Application number: 2023/91280	
What is the application for?:	Quarrying operations for the extraction of clay, shale and incidental coal and s
Address of the site or building:	Bromley Farm Quarry, Barnsley Road, Upper Cumberworth, Huddersfield, HD8 8PD
Postcode:	S36 4HG

Type of comment: An objection	
Do you wish your comments to be published on the website anonymously?	Yes
Dear Sirs, Once again the timing of the posting updates is suspect and inconvenient, not allowing for many affected residents to make their objections heard within the given timeframe over the Christmas period. May I also ask why my previous 'Objection' is now showing as a 'Comment'? Concerning the newly submitted documents: Why am I looking at, or expected to react to an 'Air Quality Assessment' for GRANTHAM? Does the applicant have such little respect for the residents of this area, and the process for application, that they dont even submit relevant documentation? Why does the 'Ecology Report' suggest that the area surrounding the quarry...and indeed Upper Cumberworth, would appear to be BARREN of flora, fauna, and wildlife that would be negatively impacted by quarrying on the site? Any valid study needs to b

HGV ROUTING PLAN

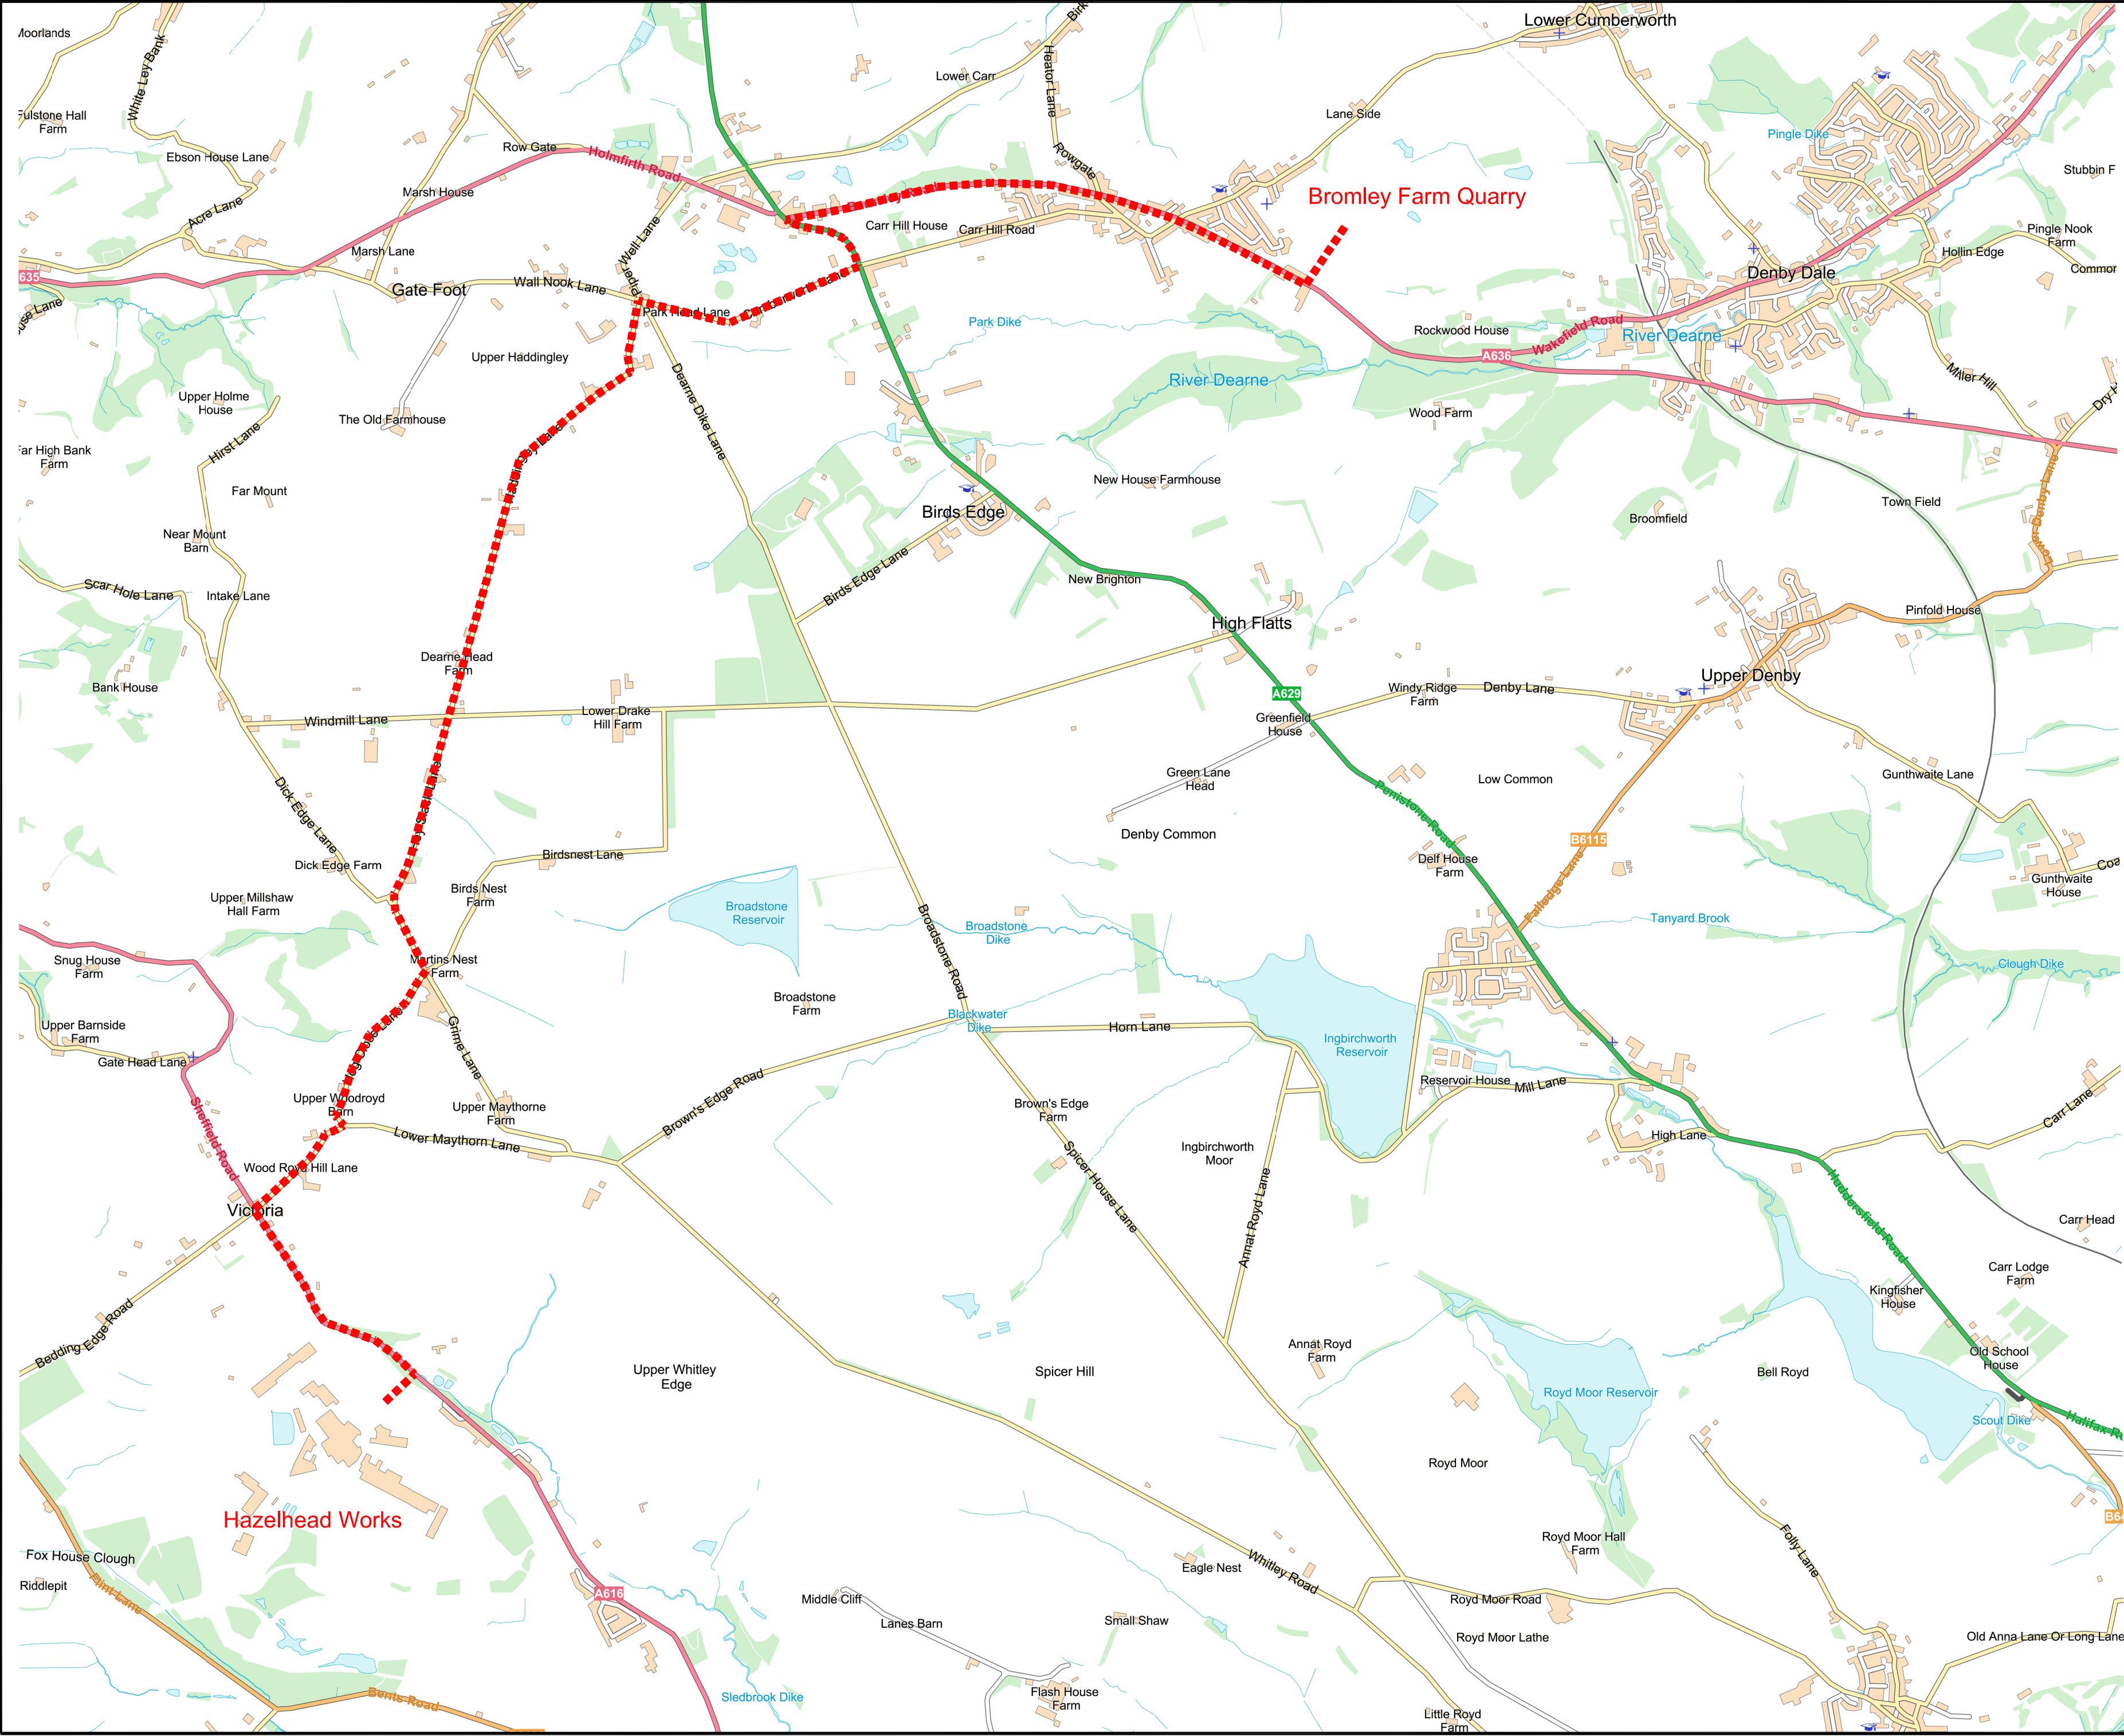
HGV routing proposal - have West Yorkshire Police been consulted on this proposal? The routing takes ARTICULATED HGVs to the Sovereign Crossroads (A notoriously dangerous blackspot) and expects them to turn left...'uphill' on an ADVERSE CAMBER (A road design feature that involves the road surface sloping away from the inside of a bend, being higher on the inside of the bend than on the outside where the camber of the road may have a negative impact on the handling of the vehicle, or load stability)!! TWO reasons, which in themselves, should prevent this from being a route for consideration. The other route of using CARR HILL ROAD is also NOT an option as it would involve the ARTICULATED HGVs turning left whilst using the FULL width of the road, a dangerous manouver for oncoming vehicles, and then proceeding up a residential road that is not wide enough to permit the passing of pedestrians etc. and other vehicles in line with Road Safety Regulations.
